**RMS AND TfNSW CONSULTATION MEETING MINUTES
STATE SIGNIFICANT DEVELOPMENT (SSD) 9210
PROPOSED SAINTS PETER AND PAUL CHRISTIAN PRIMARY SCHOOL
17-19 KOVOVICH PLACE, CECIL PARK (LOT 2320 & 2321 DP 1223137)**

Meeting Time and Date: 1pm, 23 July 2018

Meeting Location: Transport for NSW Offices

CLIENT / Project:
Saint Peter & Assyrian Primary School

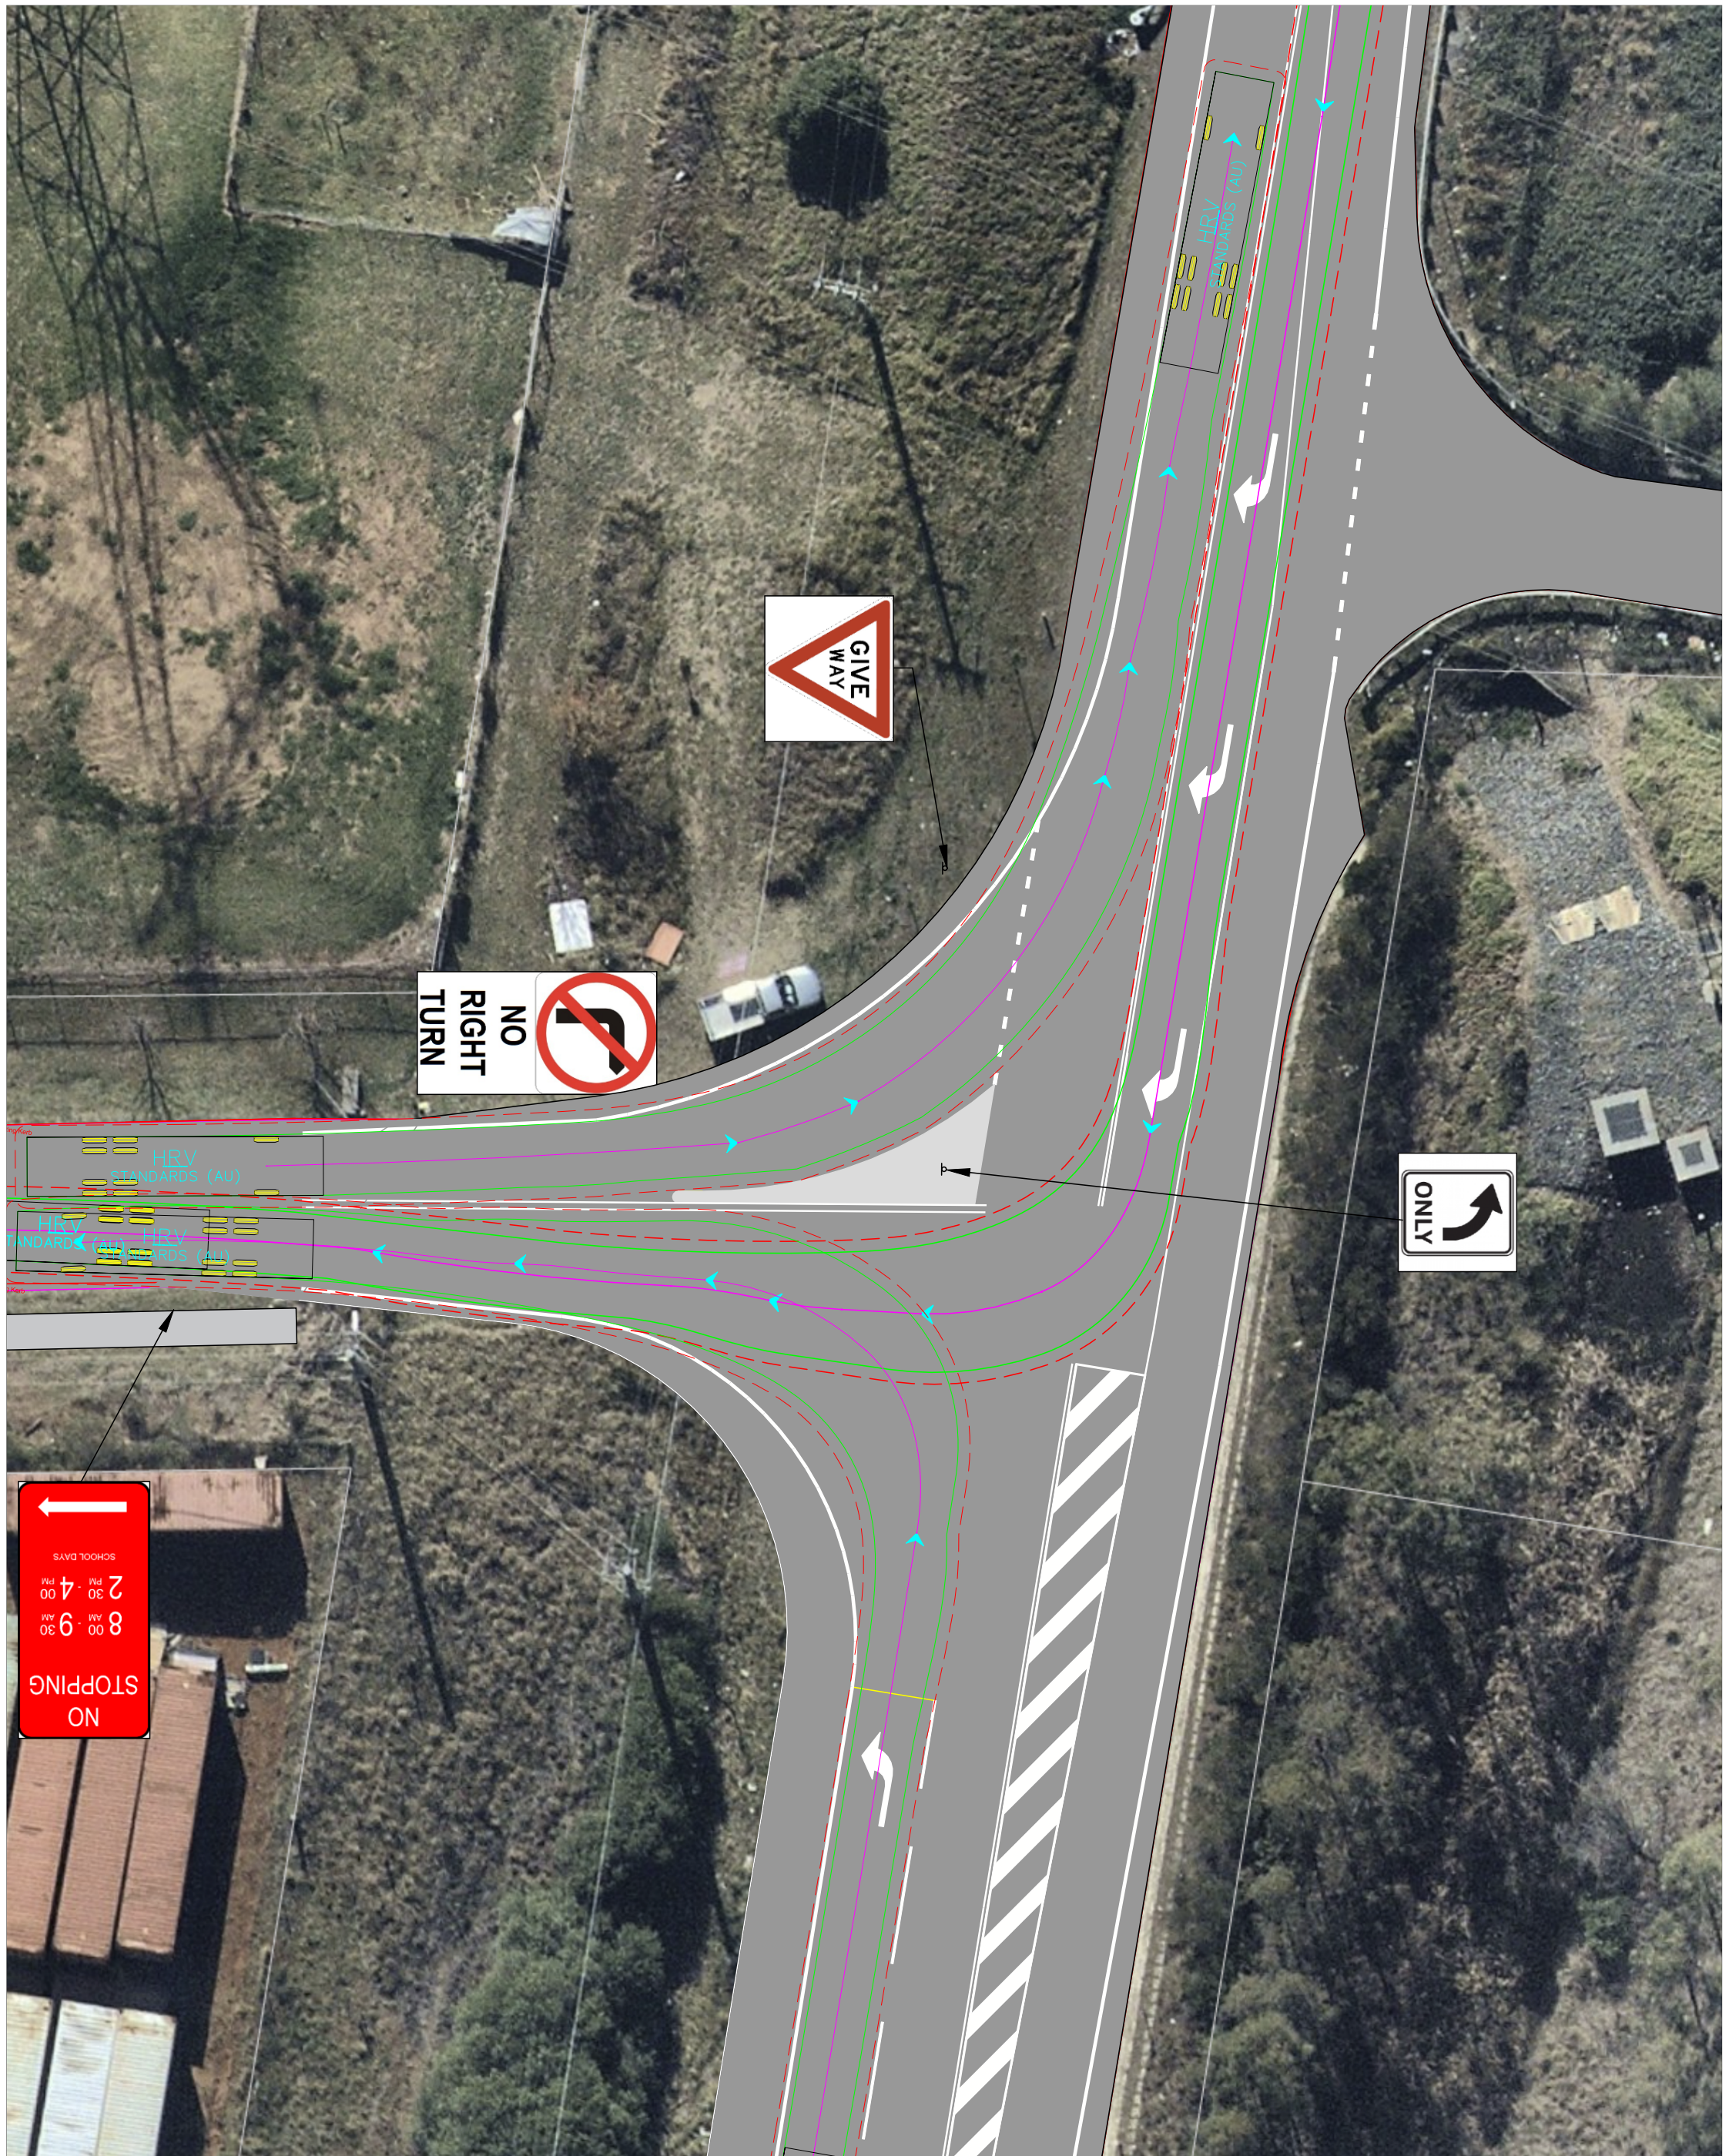
- Further to the work carried out with the local bus operator (Transit Systems), RMS request that swept paths for buses in the Kosovich Place cul-de-sac are submitted with the DA.

Revision	Date	Details
A	12/07/2018	
B	20/07/2018	Storage length and road width shown
C	05/02/2020	Left Turn Decel Added

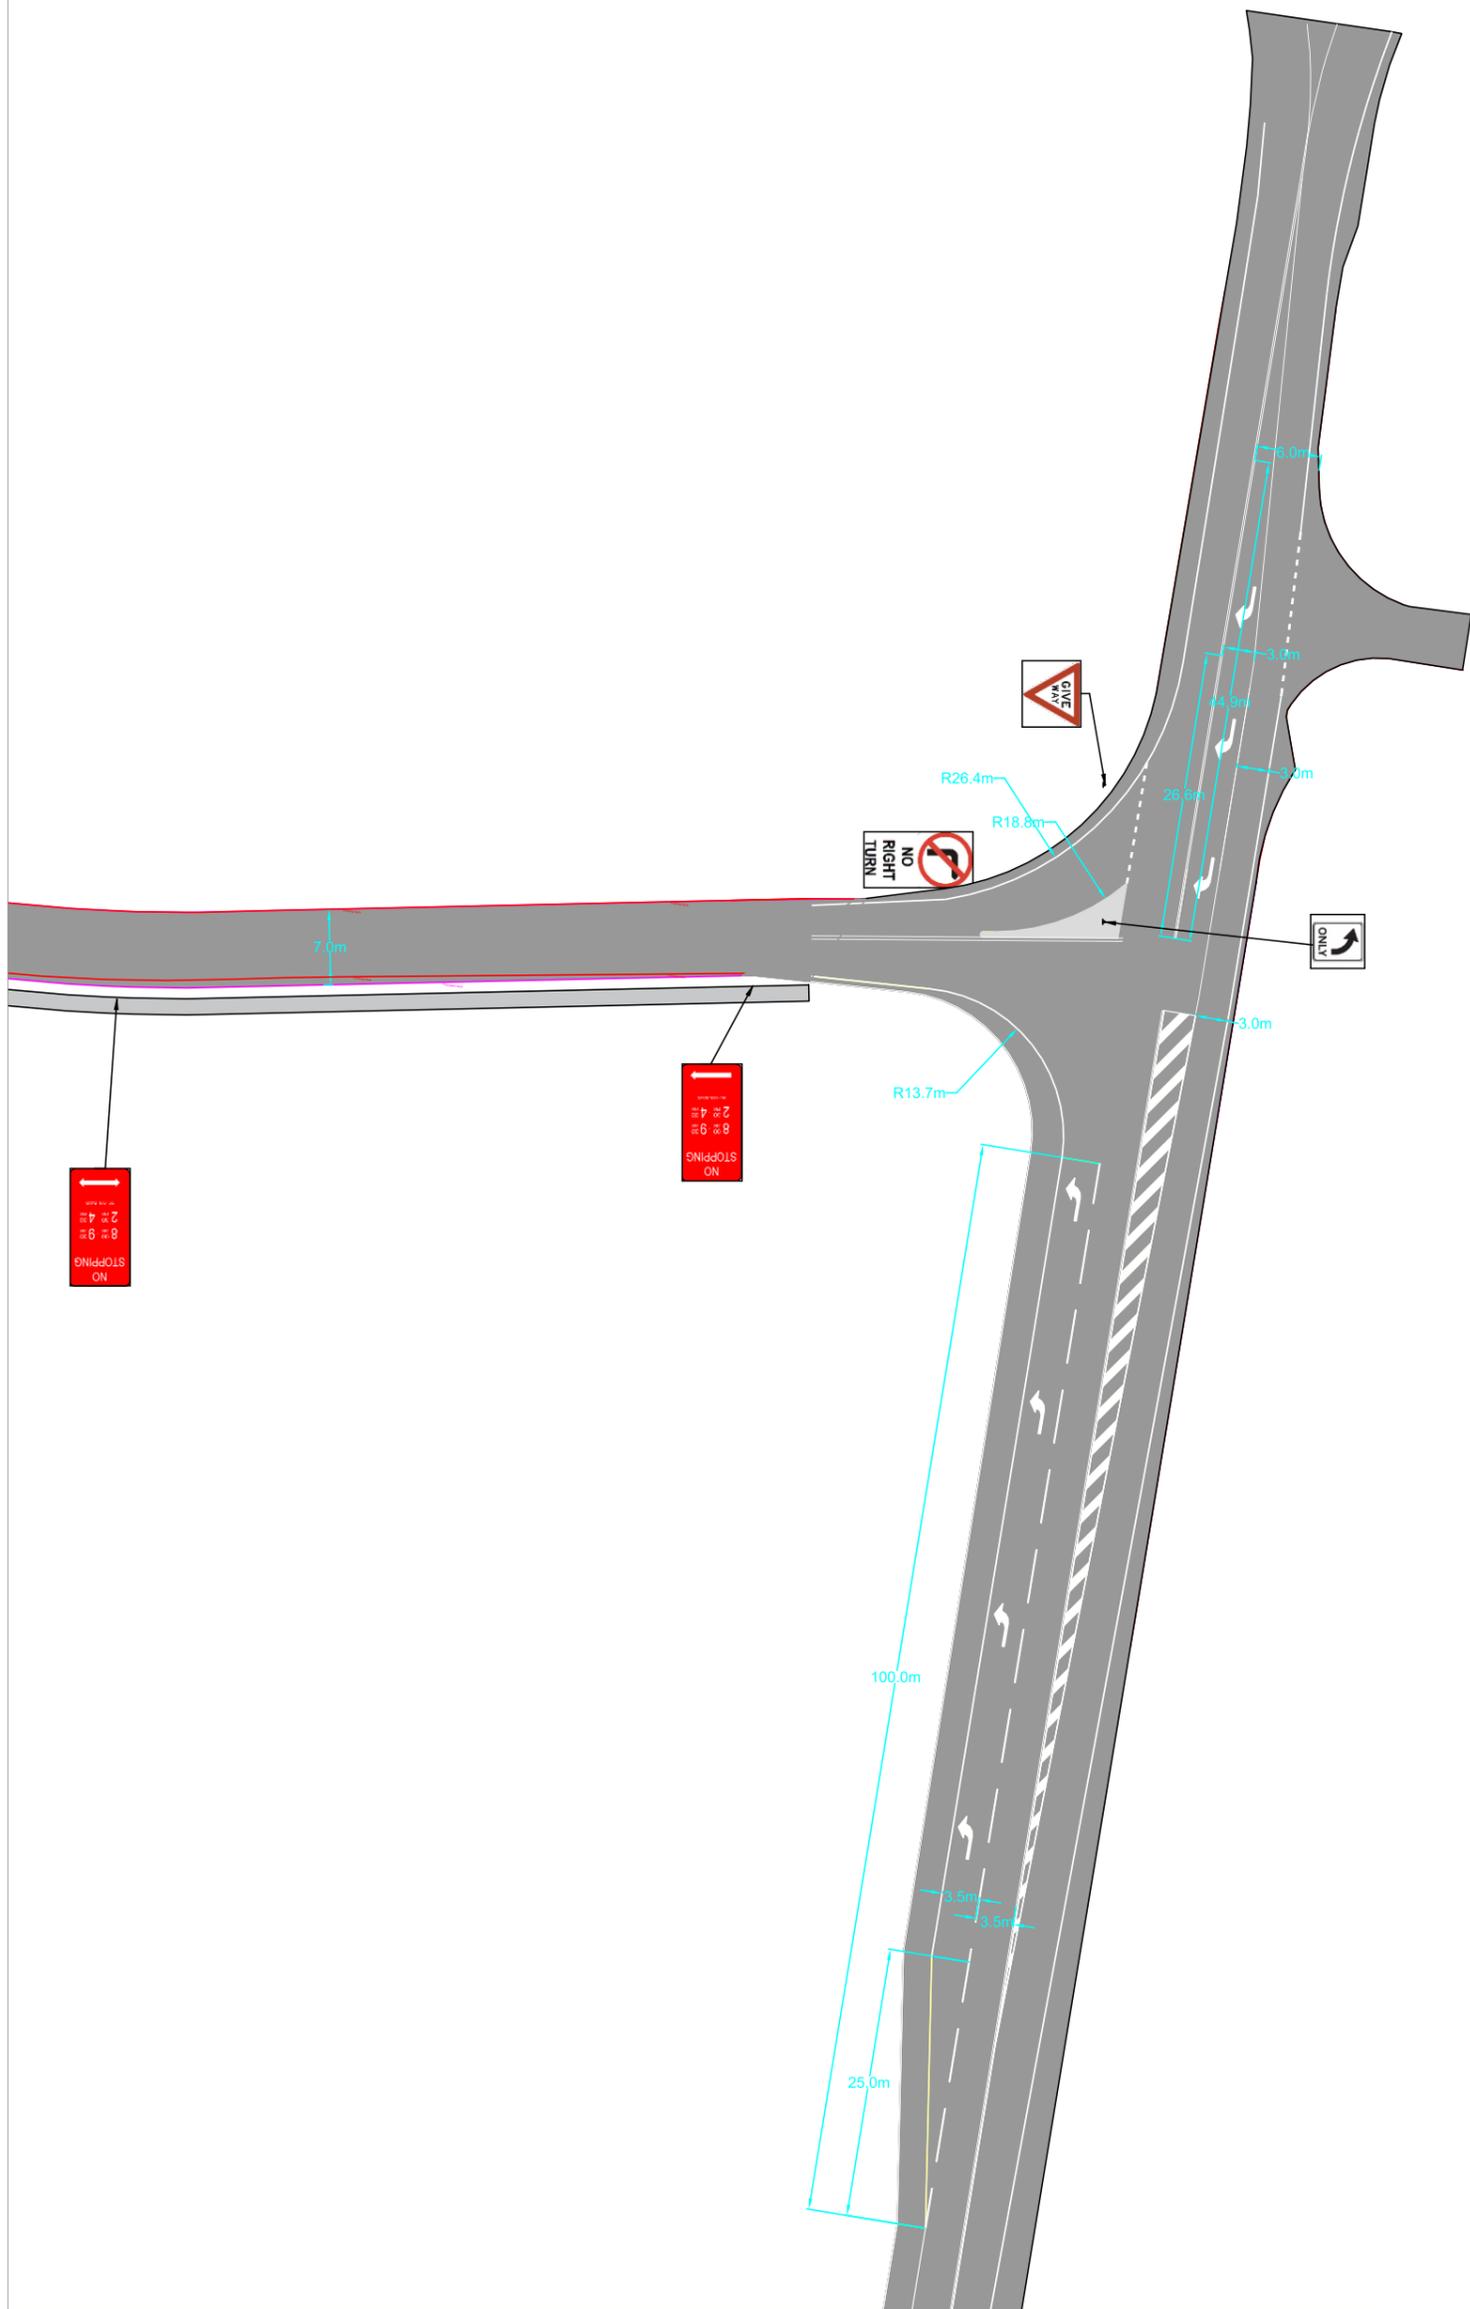
- The proposed 25m right-turn lane from Wallgrove Road to Kosovich Place is not supported by RMS, on the following basis:
 - Proximity of the intersection to the existing roundabout (Wallgrove Road and Villers Road), resulting in safety concerns. The proposed 25m length of the right-turn lane does not comply with Australian Standards as applicable to deceleration lanes on a State road with an 80km/h speed limit. These safety concerns persisted despite the following being clarified by the Project Traffic Engineer:

- SIDRA Modelling demonstrates that the 25m right-turn lane would provide adequate storage for queued cars.
 - Owing to the proximity of the roundabout, traffic would be travelling at speeds much lower than 80km/h.

- The current volume of traffic carried by Wallgrove Road was clarified to be much lower than the figures initially quoted by RMS. Current volumes are estimated at 838 northbound vehicles in the AM peak hours and 987 southbound vehicles in the PM peak hour.
